LIBERTY TREE ACADEMY CONSTRUCTION DOCUMENTS

TOWN OF PEYTON, EL PASO COUNTY

PRELIMINARY DESIGN

MAY 2018

| REFERENCE DRAWINGS | | | |

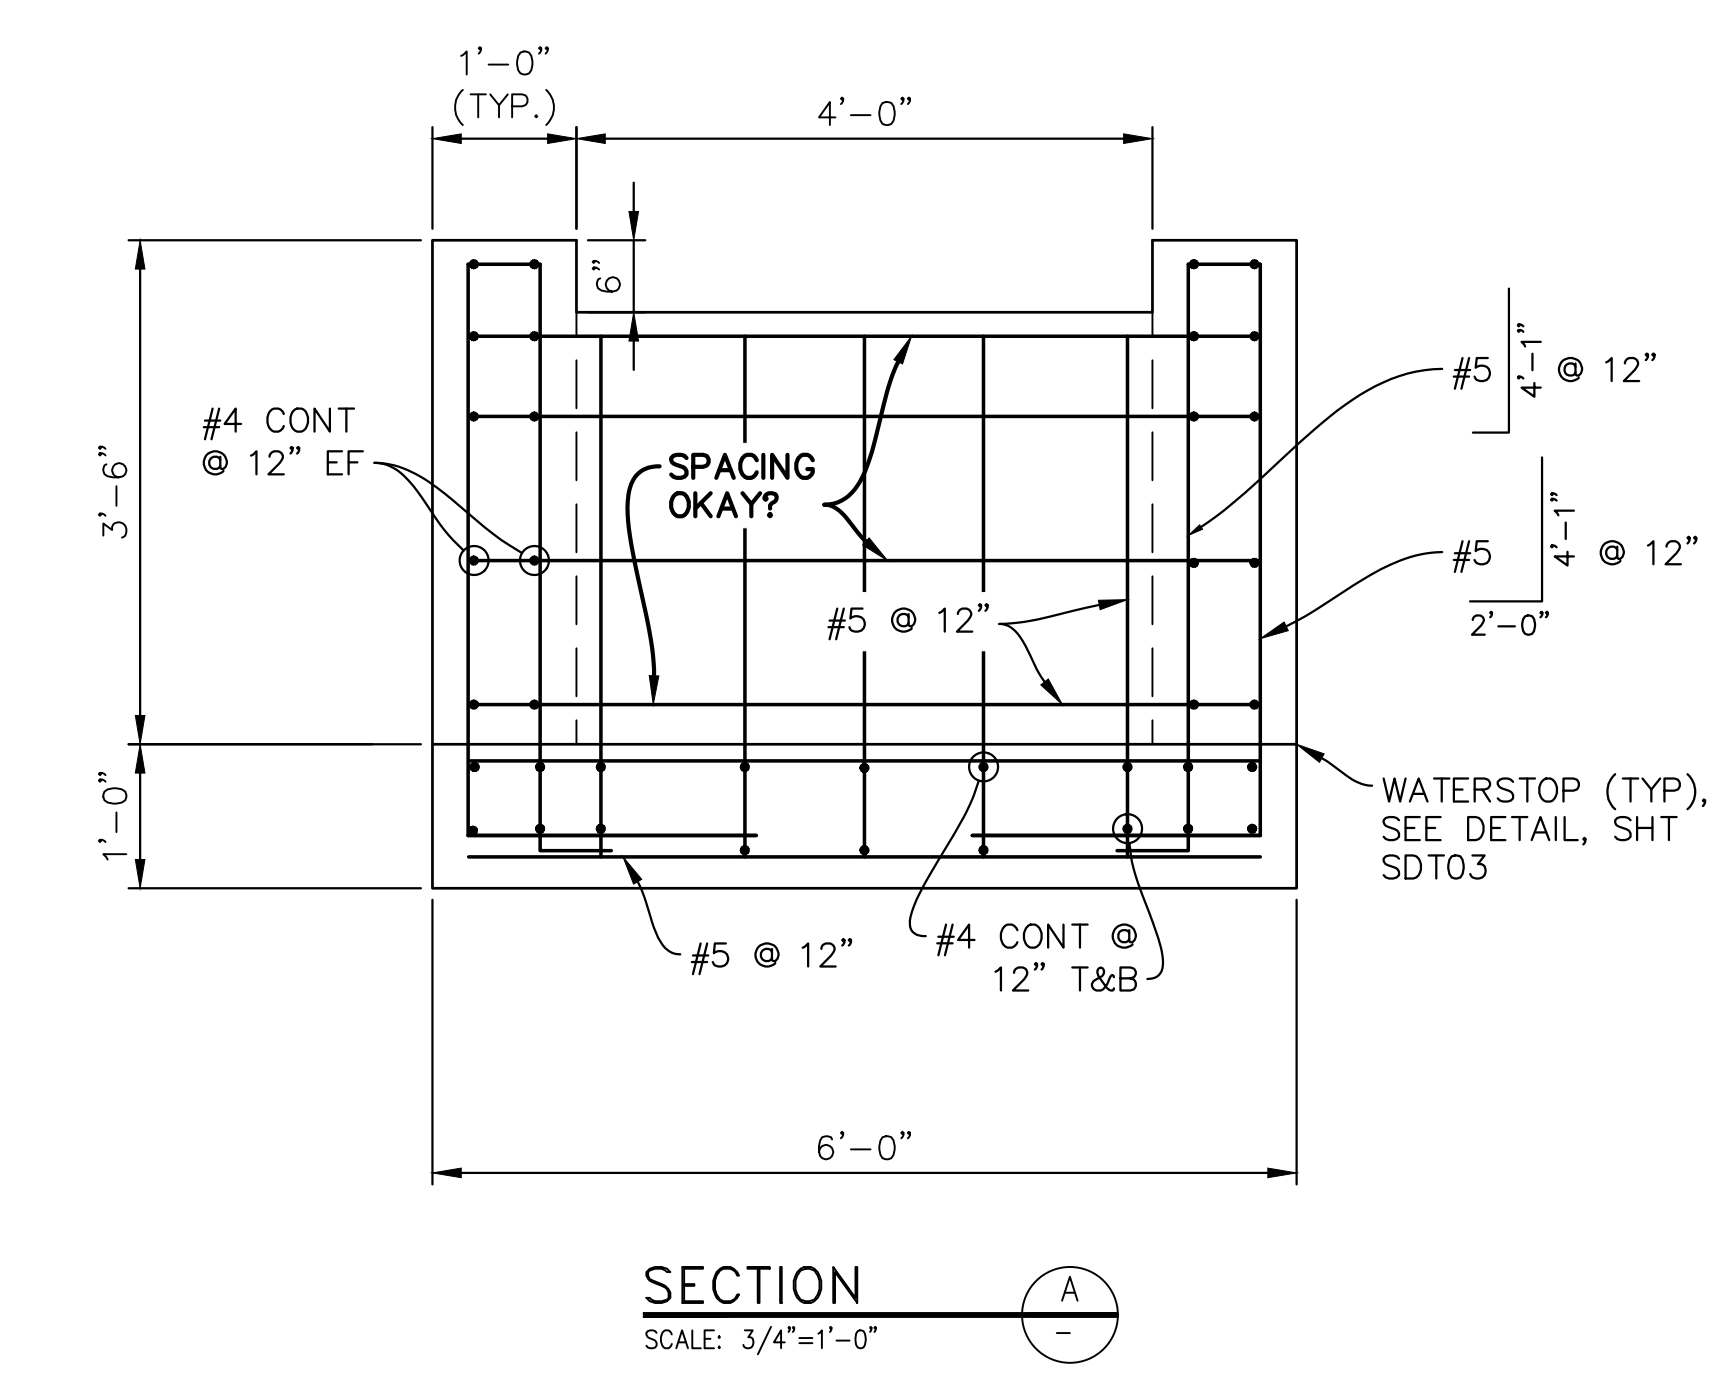
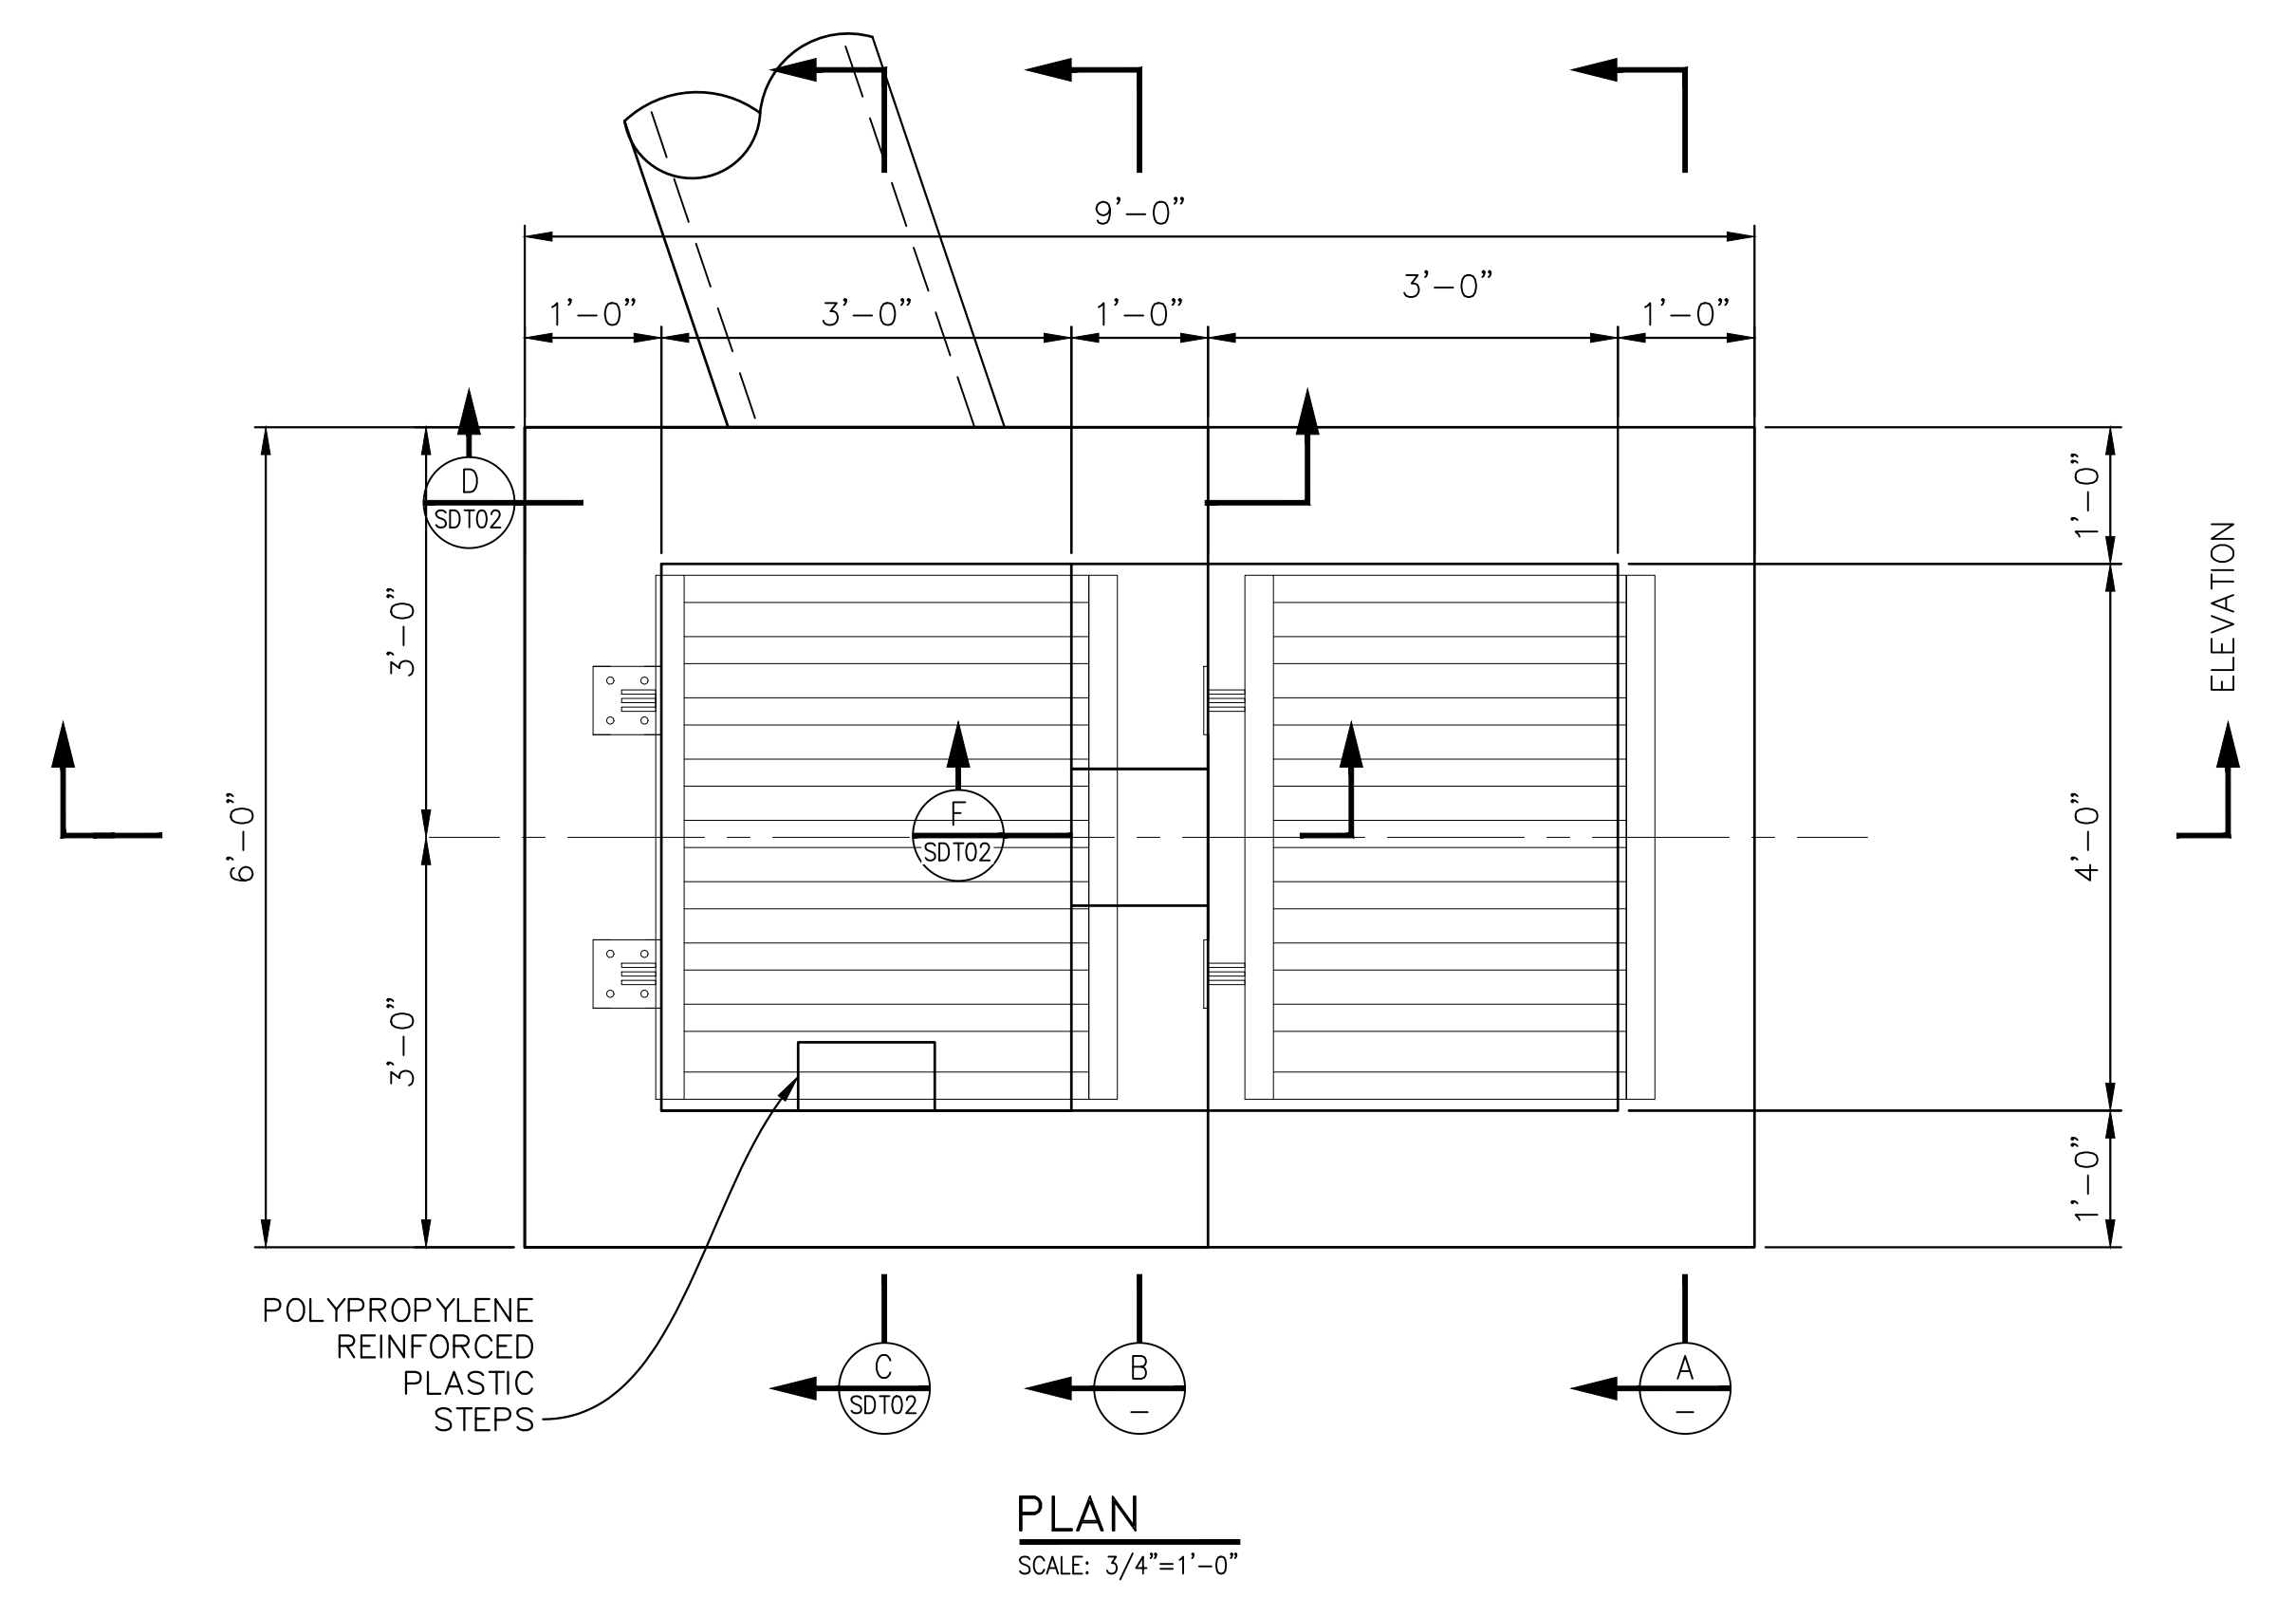
Pipe doesn't match. Address outfall protection.
